VOLLMER ROAD (NORTH)

STREET IMPROVEMENT PLAN

AS-BUILTS
04/13/2026

SHEET 3 OF 17
 JOB NO. 25188.00

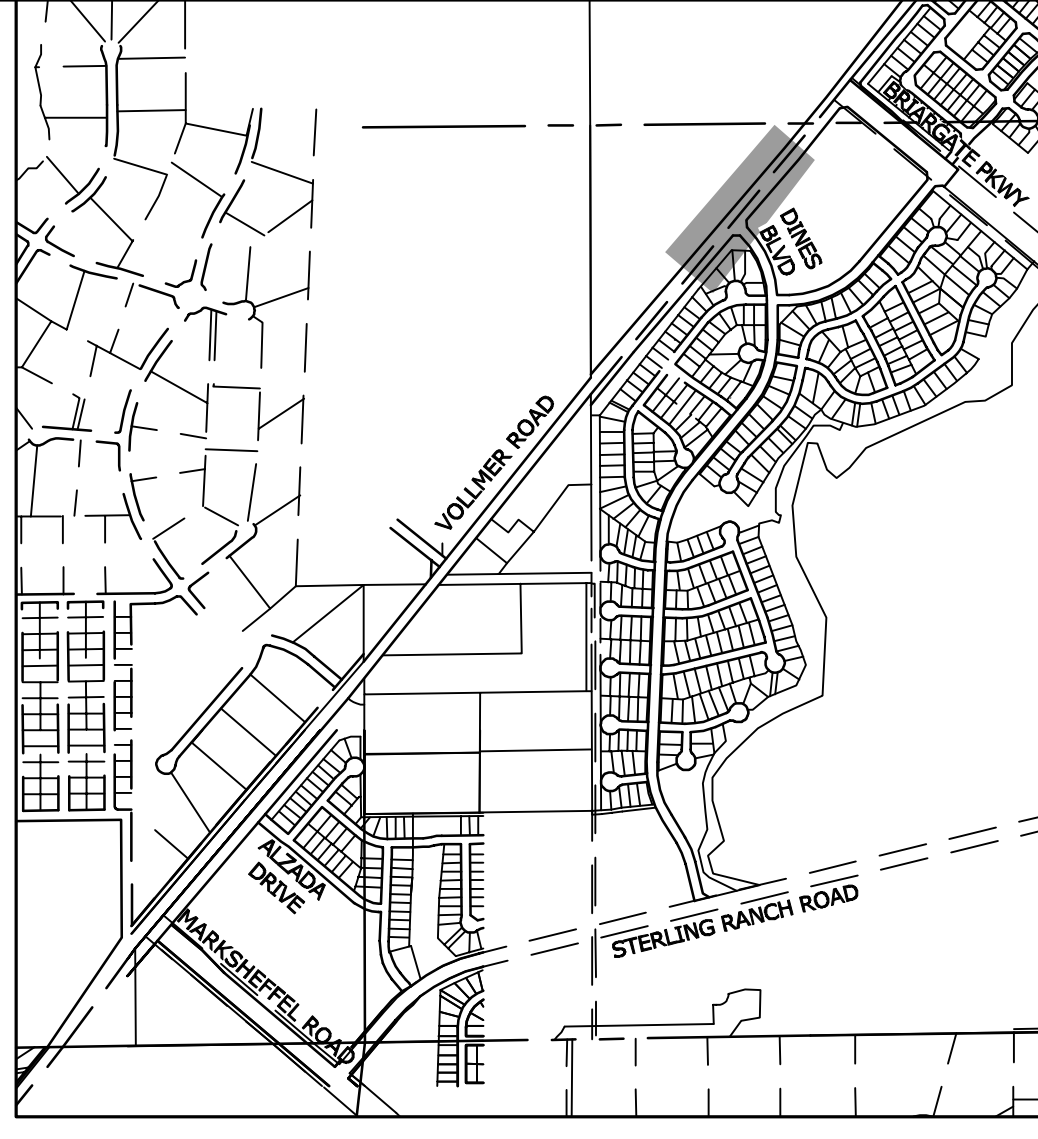
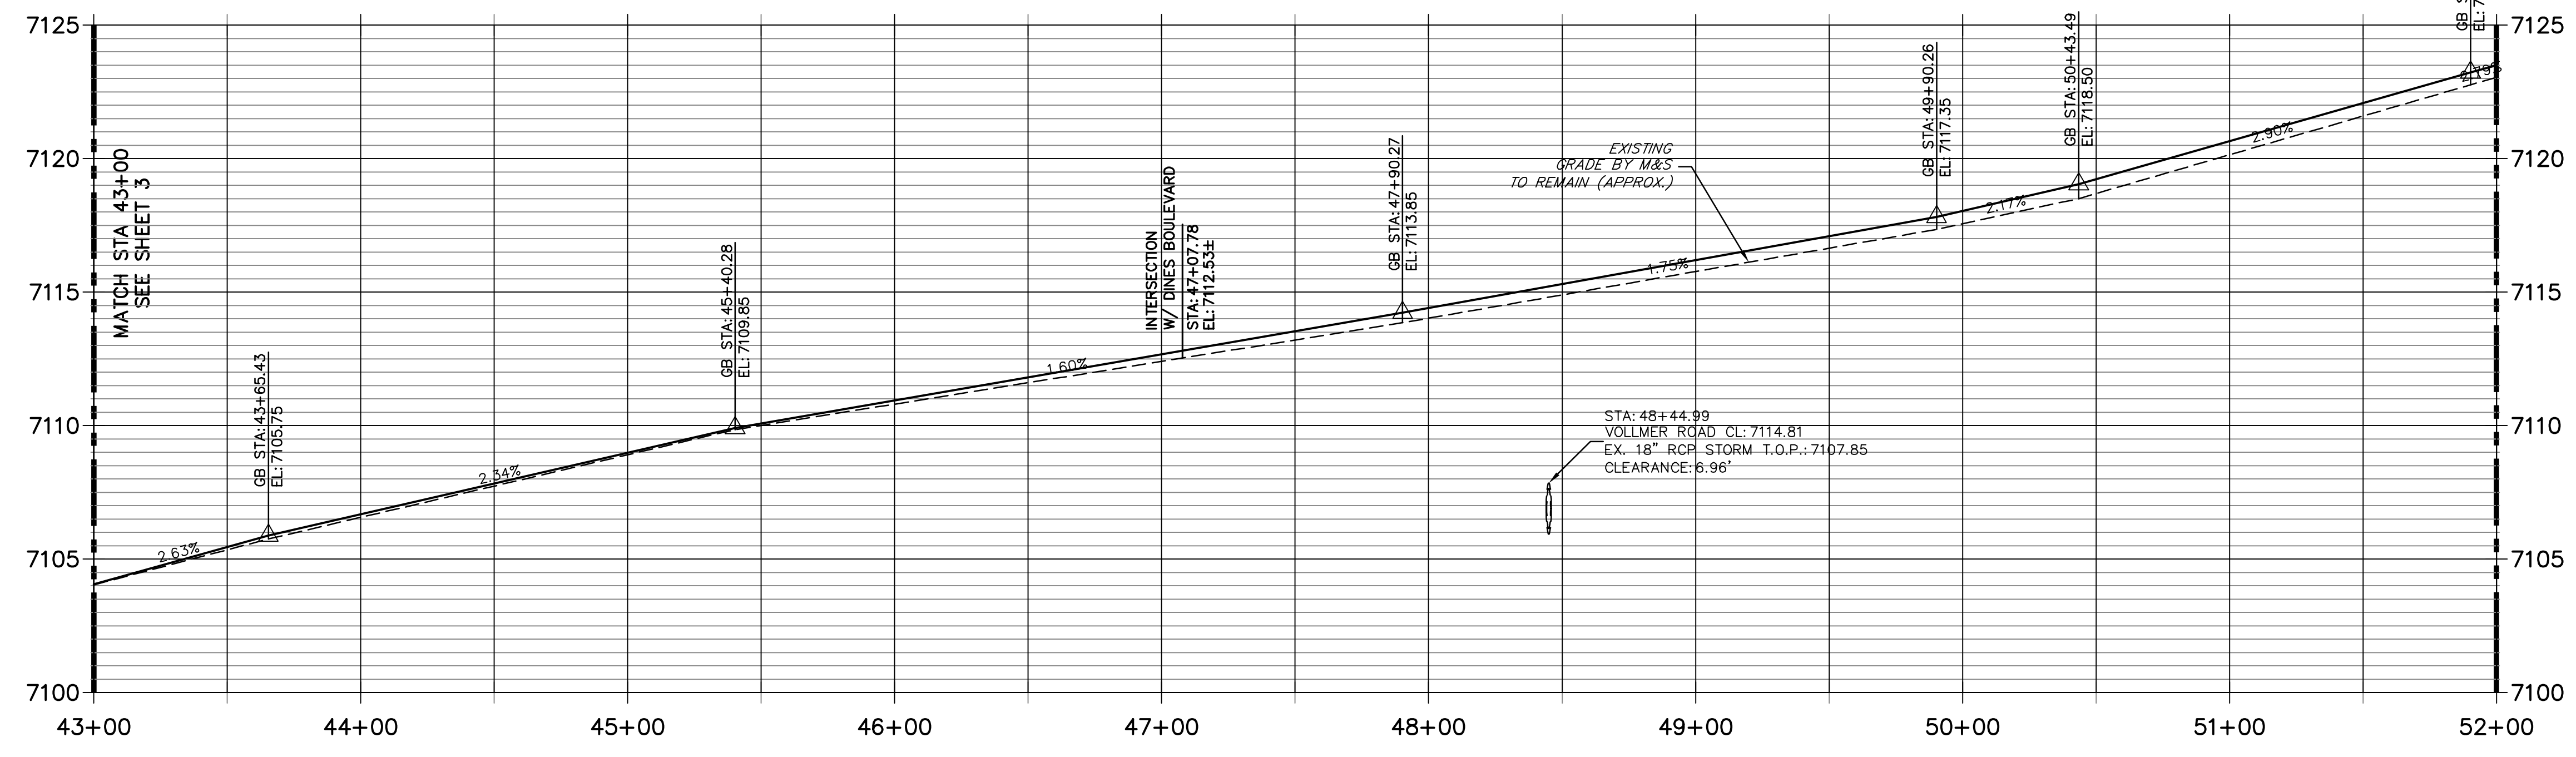
Unresolved Review 1 and 2 comment.
 Review 3 comment:
 The developer/contractor flow filled this pipe with slurry recently on 4/24. Please update this note to be accurate.
JR Response: Addressed
